From: Nicola Spencer on behalf of Planning
Sent: 02 January 2019 12:42
To: Planning Scanning; Planning.Responses
Subject: FW: A/158/18/PL - OBJECTION
Attachments: Objection_A15818PL_28_12_18.pdf

Variation of condition 1 imposed under A/8/18/PL relating to the substitution of approved plan drawings NO ADC 962 04 rev A & 13 rev B for drawings No ADC 962 20 & 21 (ground & first floor plans & roof plan). This application affects the character & appearance of the Angmering Conservation Area.

We are residents of No.5 The Cottrells and object to planning application A/158/18/PL because:

Rev	Description	Date
Job Reference		
New House The Cottrells Angmering, BN16 4AF		Client AM Homes Ltd
Drawing Title Ground Floor Plan		Drawing No ADC962/20
Date 23.11.18	Scale 1:100	Dwg Size A3
Plot Style ADC-red	Drawn TOS	Checked AD

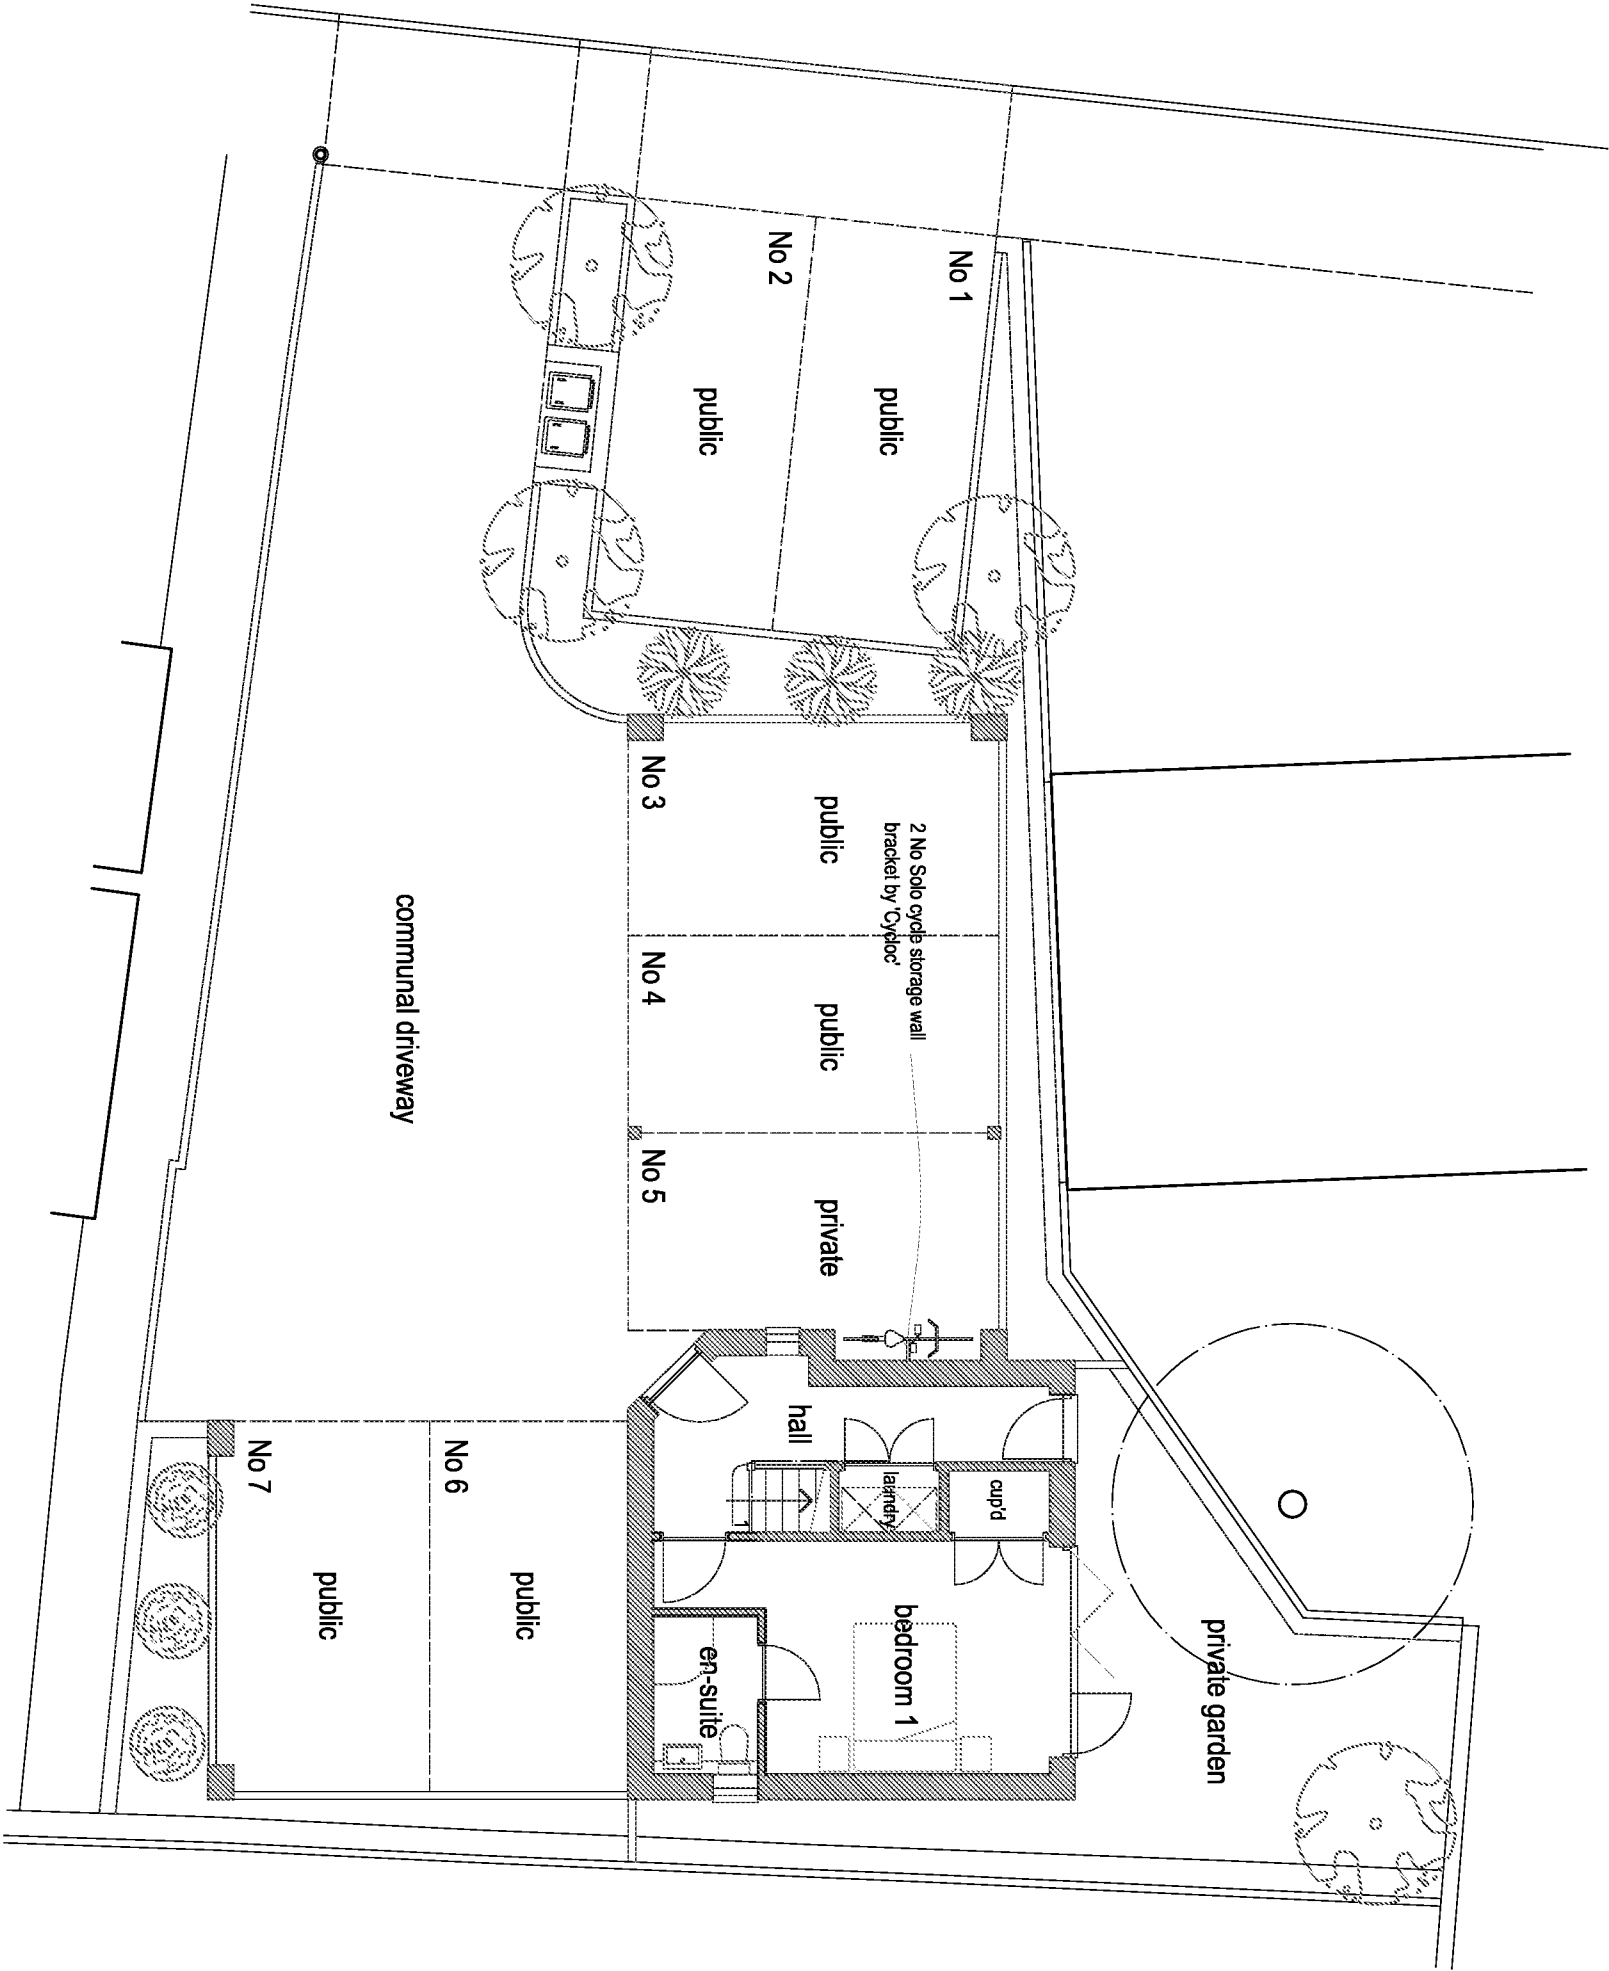
5. The internal reconfiguration allows for the potential re-purposing of the rooms from a study and 2 bedrooms to 3 bedrooms. Indeed on previous plans the 'study' has always been 'bedroom 1 or master bedroom'.

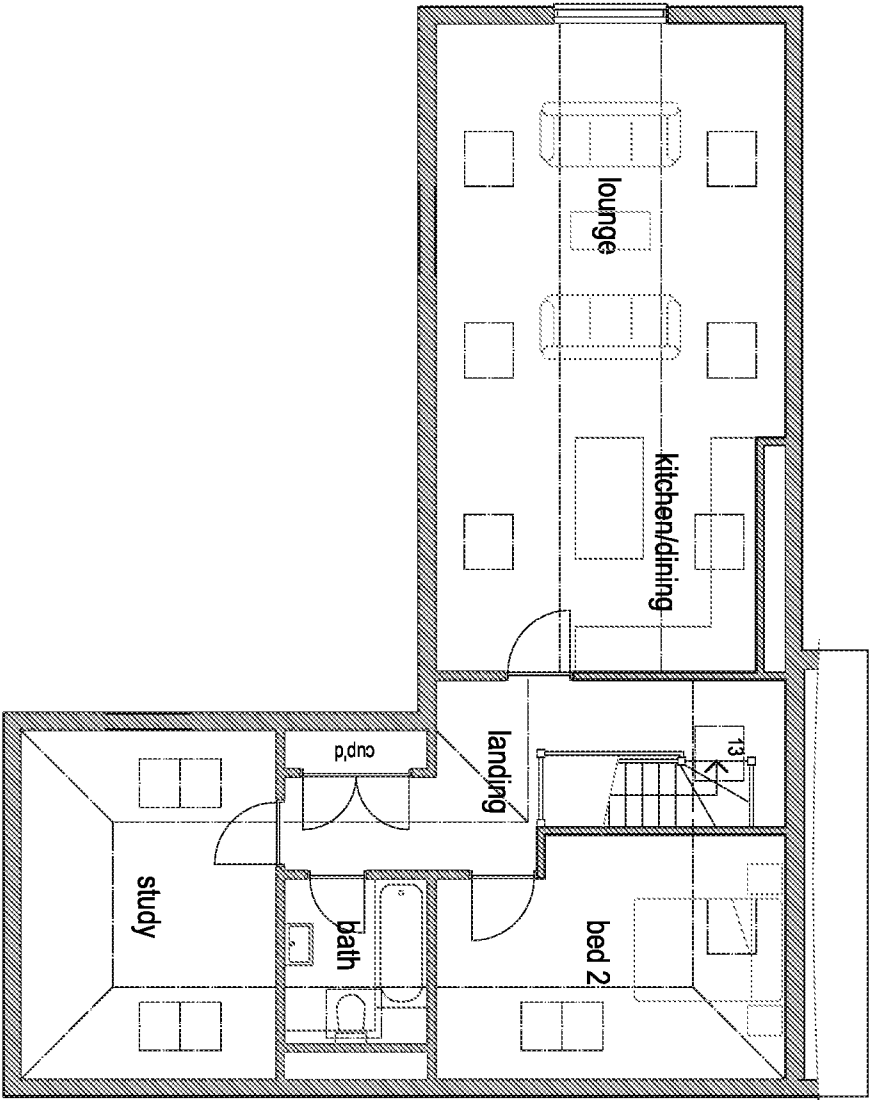
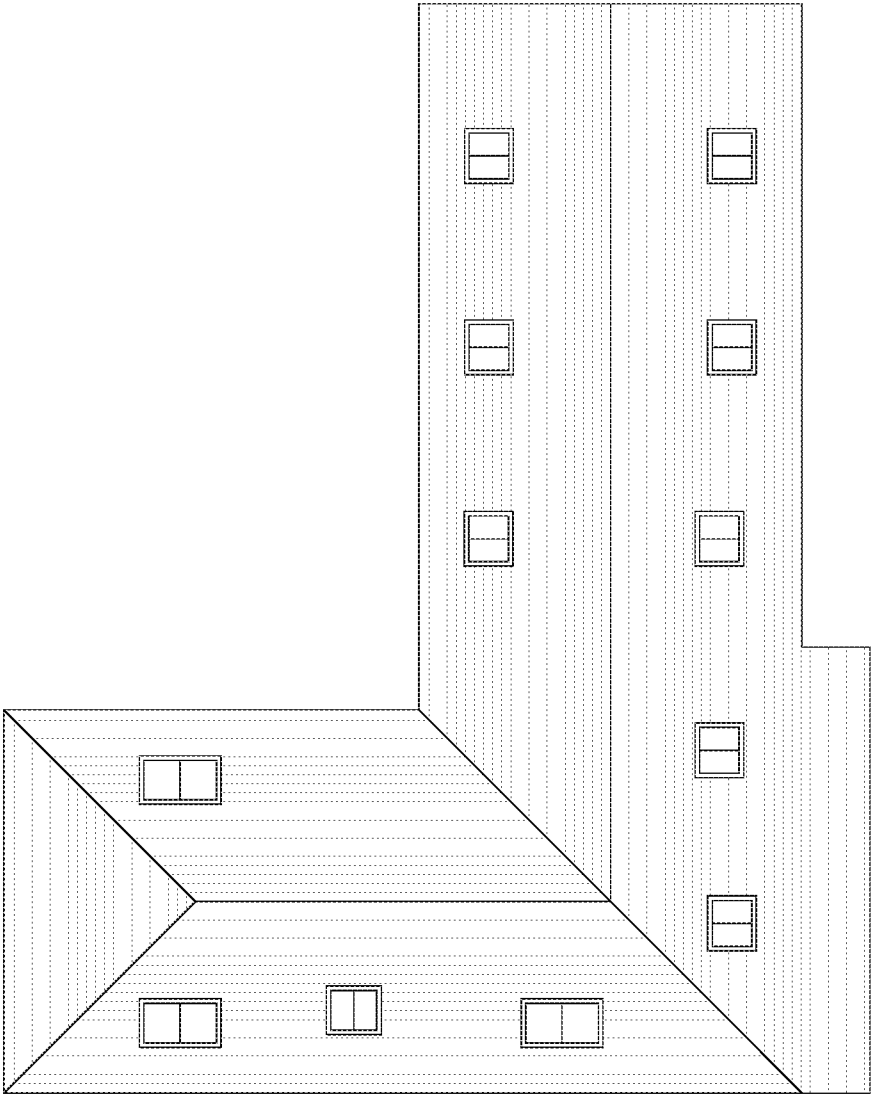
9. The windows on the approved plans are emergency roof lights installed higher up the roof than the windows currently installed. This was to protect the privacy of both the occupiers and neighbouring properties - the installed windows do not provide such privacy
